STAFF REPORT STARLITE HEIGHTS PRELIMINARY PLAT

TO: Kittitas County Hearing Examiner
FROM: Kittitas County Community Development Services Staff
RE: Starlite Heights Preliminary Plat (LP-07-16)
DATE: November 19, 2009

COVER SHEET
OF
STARLITE HEIGHTS

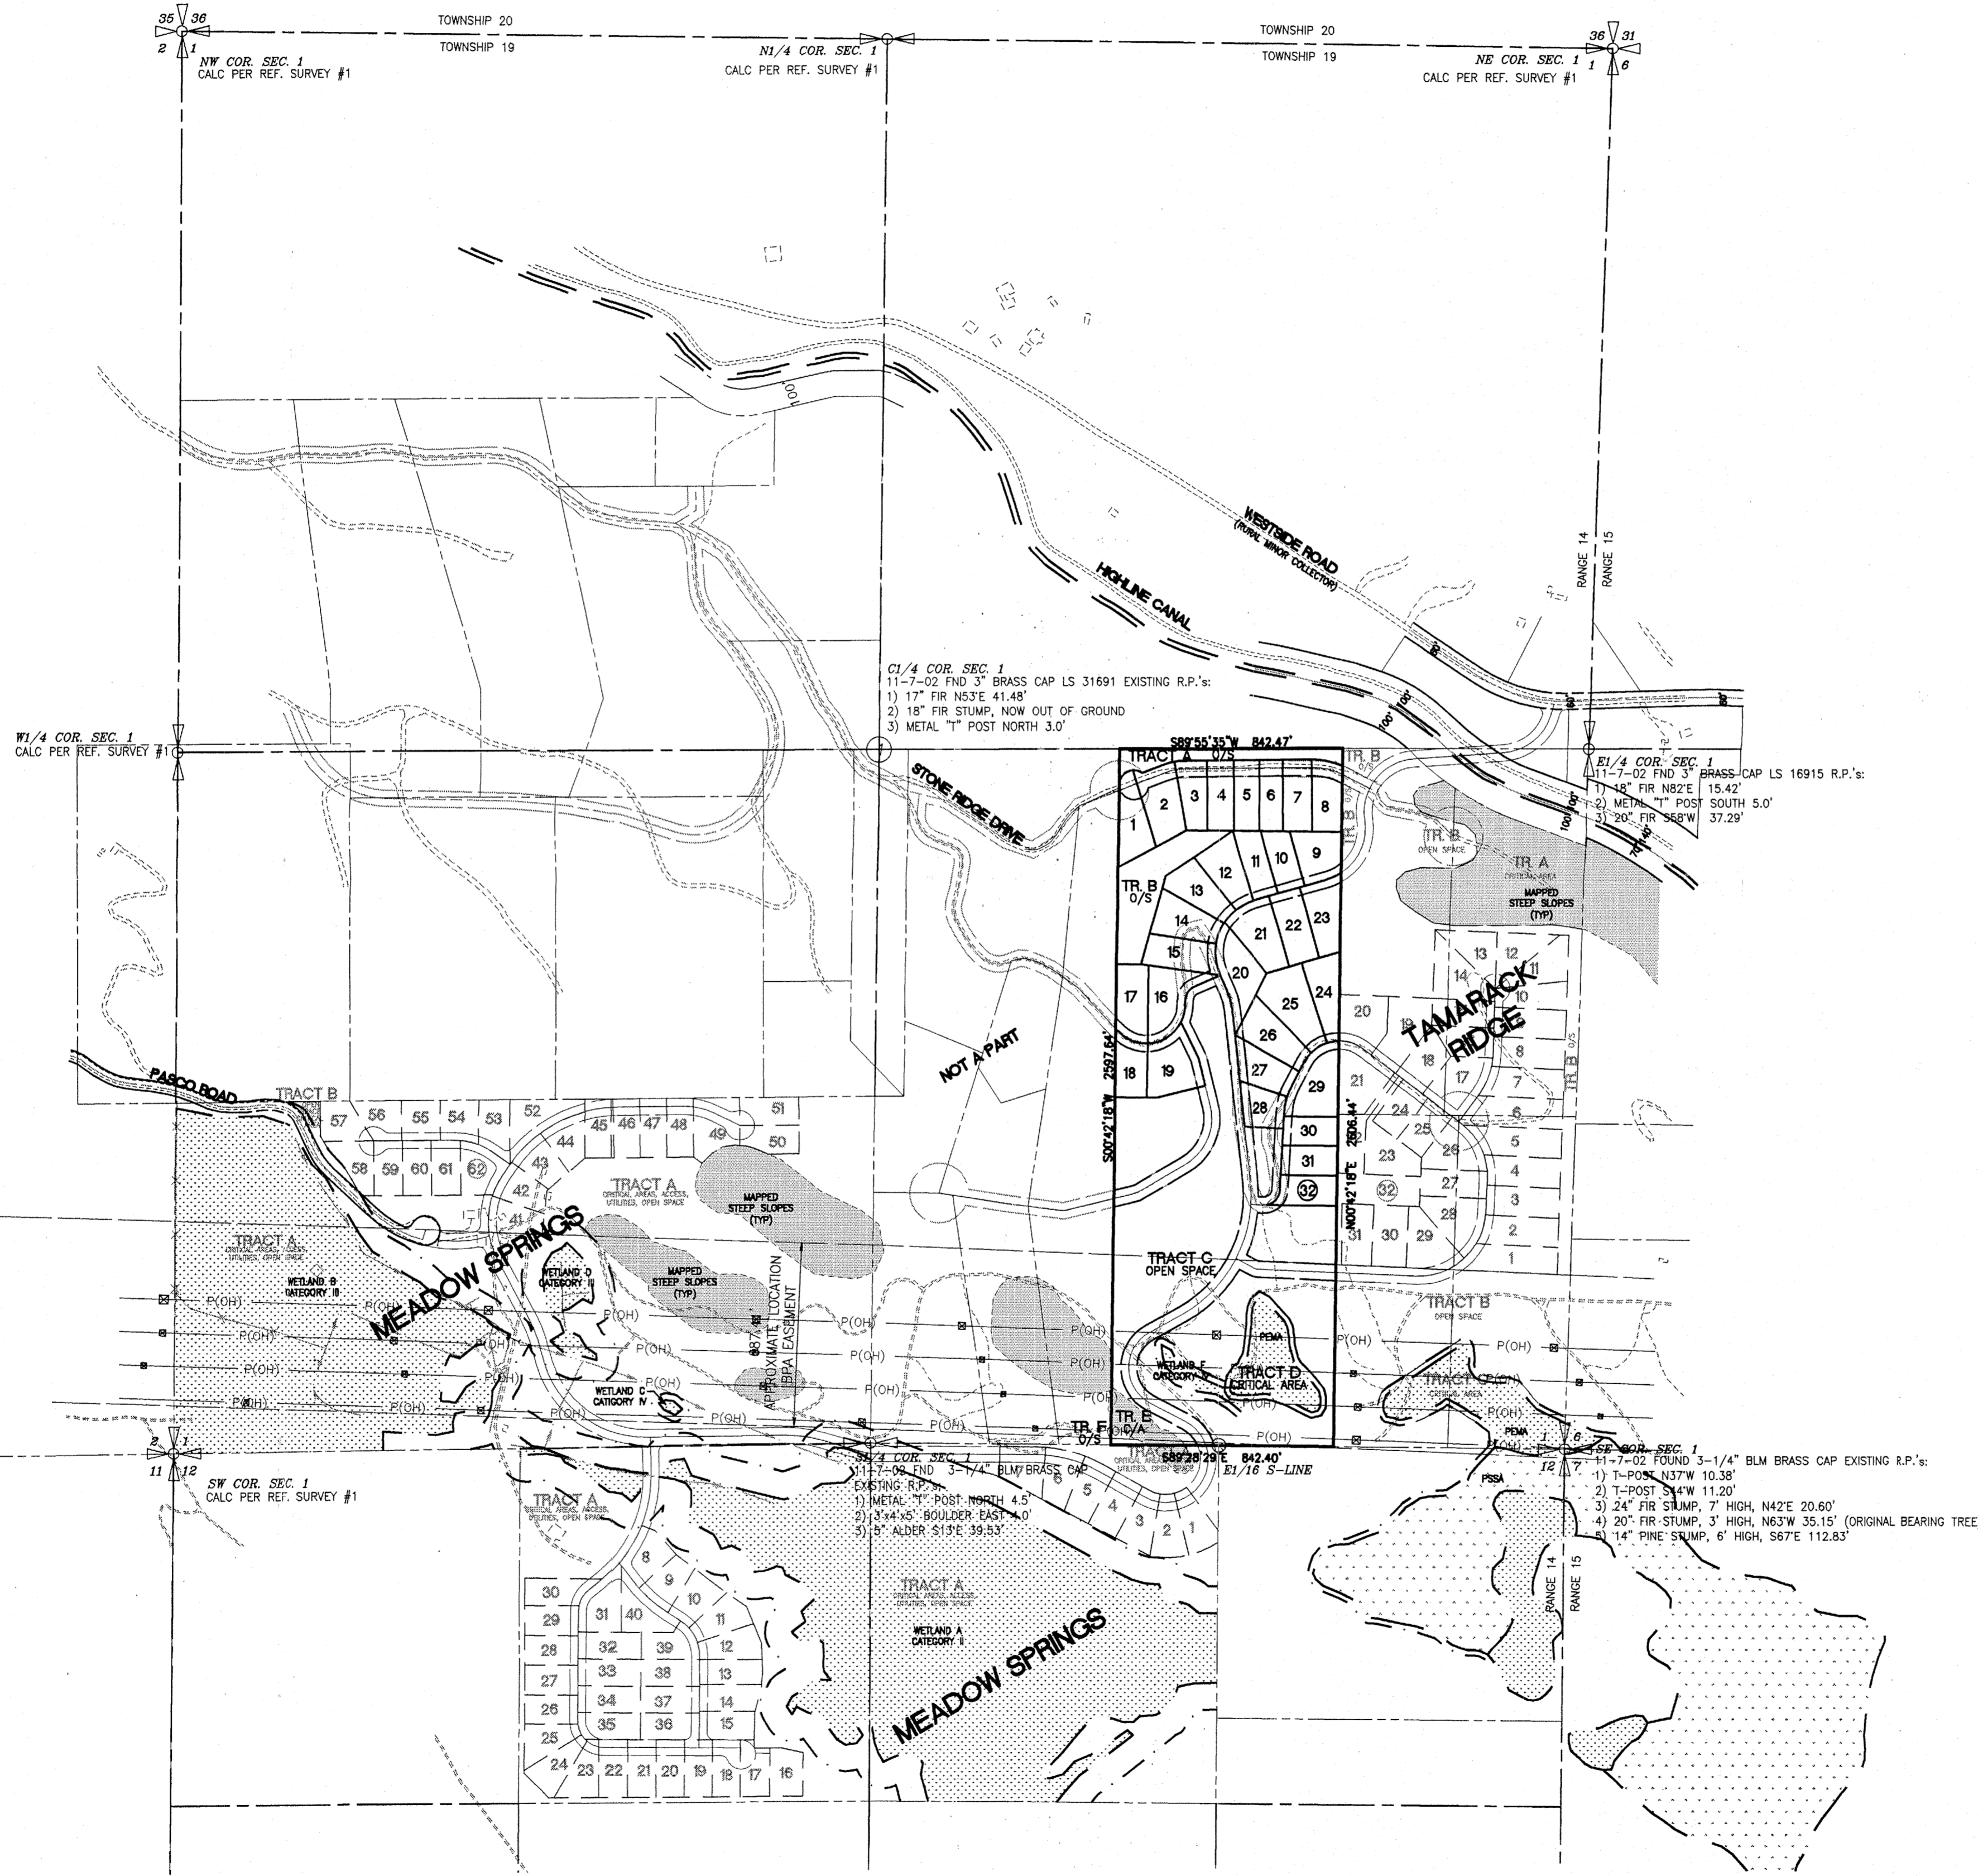
This proposal is not consistent with the Kittitas County Subdivision Code for PBCP. In accordance with KCC 16.09.030 and KCC 16.09.100C, the minimum required open space acreage for Starlite Heights is 40% of the project site, or 20.13 acres.

2. Open space calculations shall be adjusted to comply with KCC 16.09. Open space requirements shall be calculated from the total parcel size and not the total developable project area. In accordance with KCC 16.09.030 and KCC 16.09.100C, the minimum required open space acreage for Starlite Heights is 40% of the project site, or 20.13 acres. The plat shall be revised to clearly demonstrate meeting this requirement. The face of the final plat shall contain the following note: "The open space shall remain in perpetuity and can not be further subdivided."

SITE PLAN
OF
STARLITE HEIGHTS
A PORTION OF SECTION 01, TOWNSHIP 19 N., RANGE 14 E., W.M.
KITTITAS COUNTY, WASHINGTON

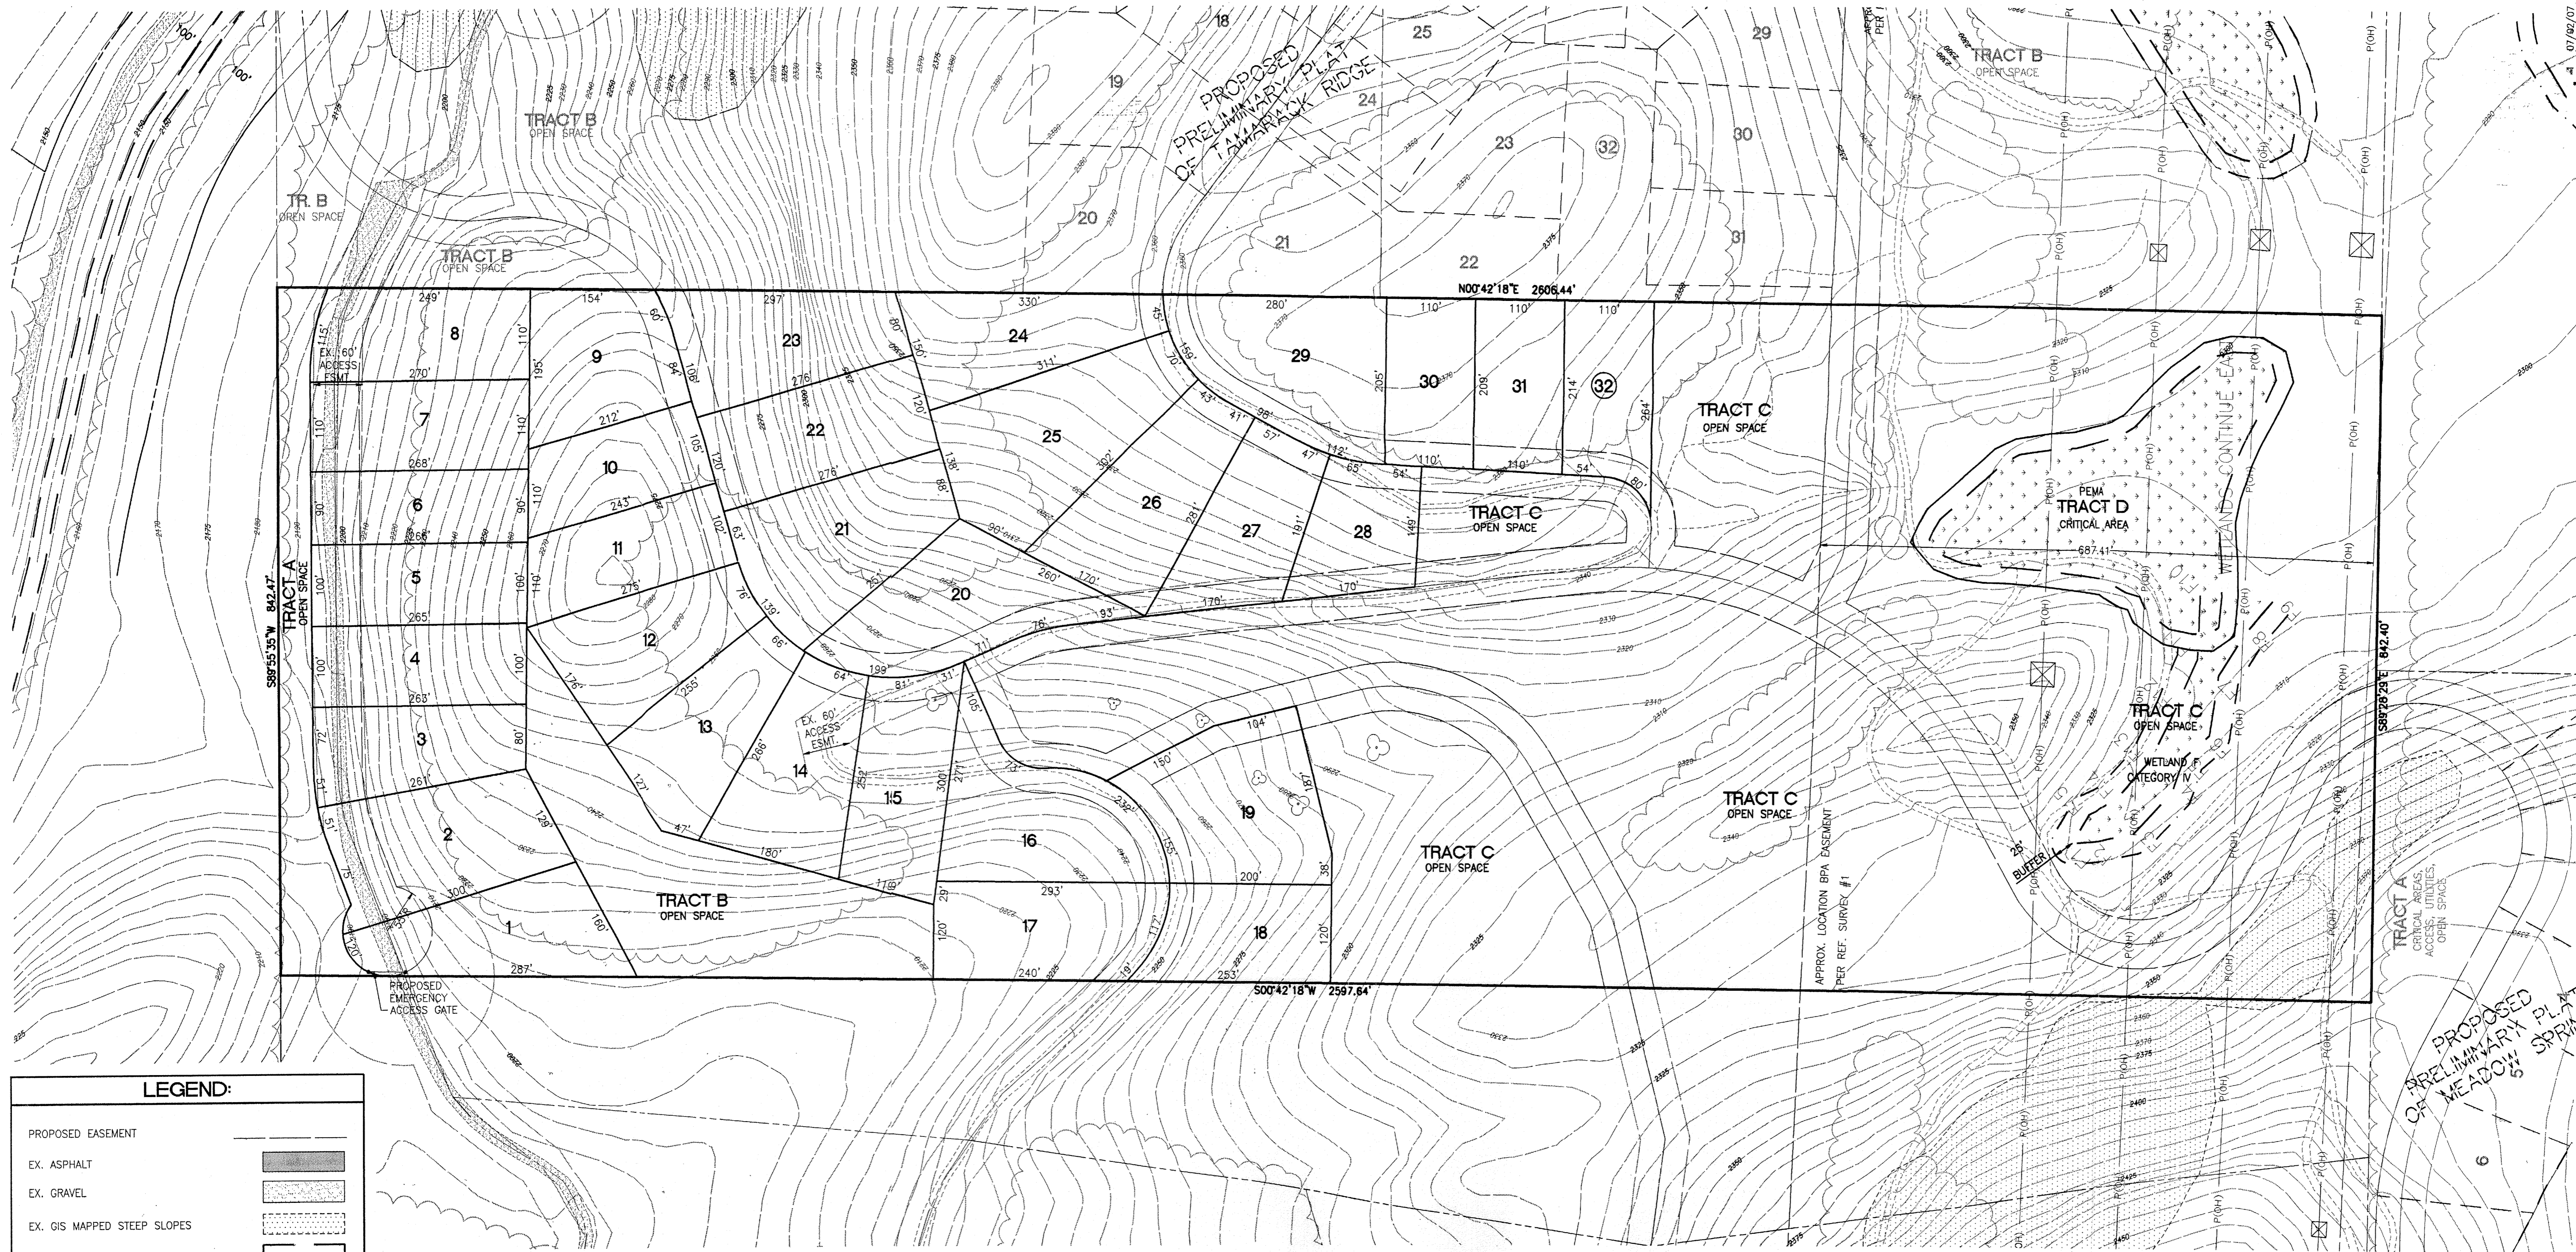
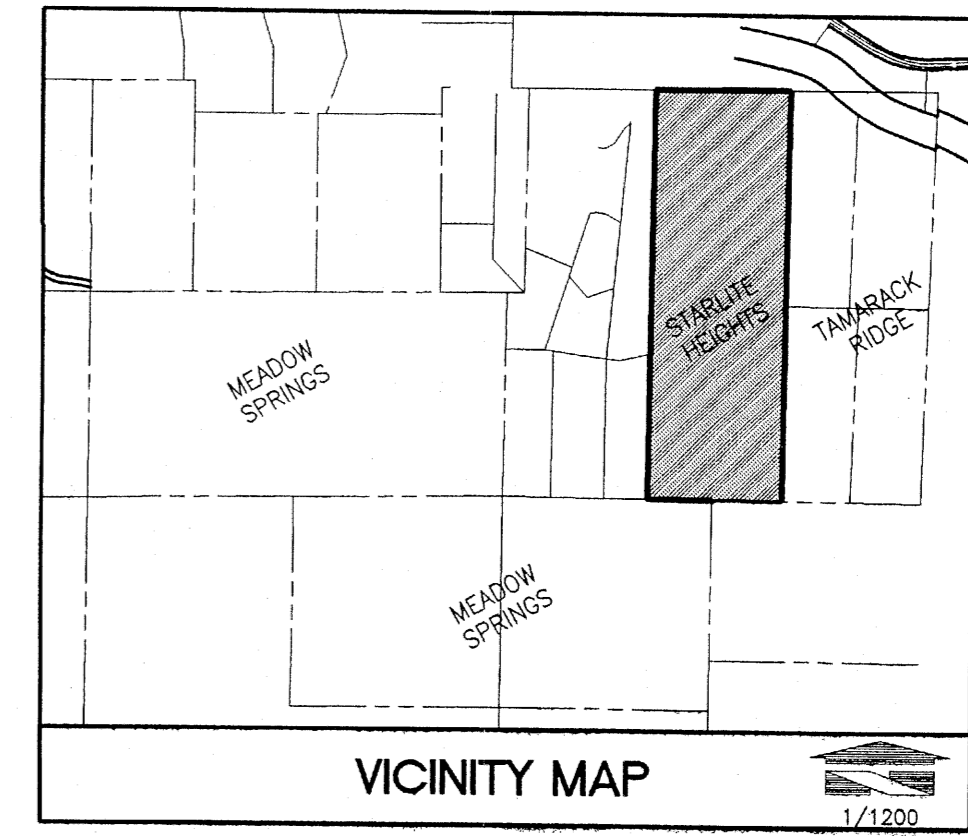
This proposal is not consistent with the Kittitas County Subdivision Code for Preliminary Plats. The page size is too large. KCC 16.12 requires page sizes to be 18 x 24 inches, and the submitted pages are 24 x 36 inches. Widths of roadway tracts are not shown. The plat does not conform to zoning regulations and lot size as required in KCC 16.12.040 and 16.12.090.
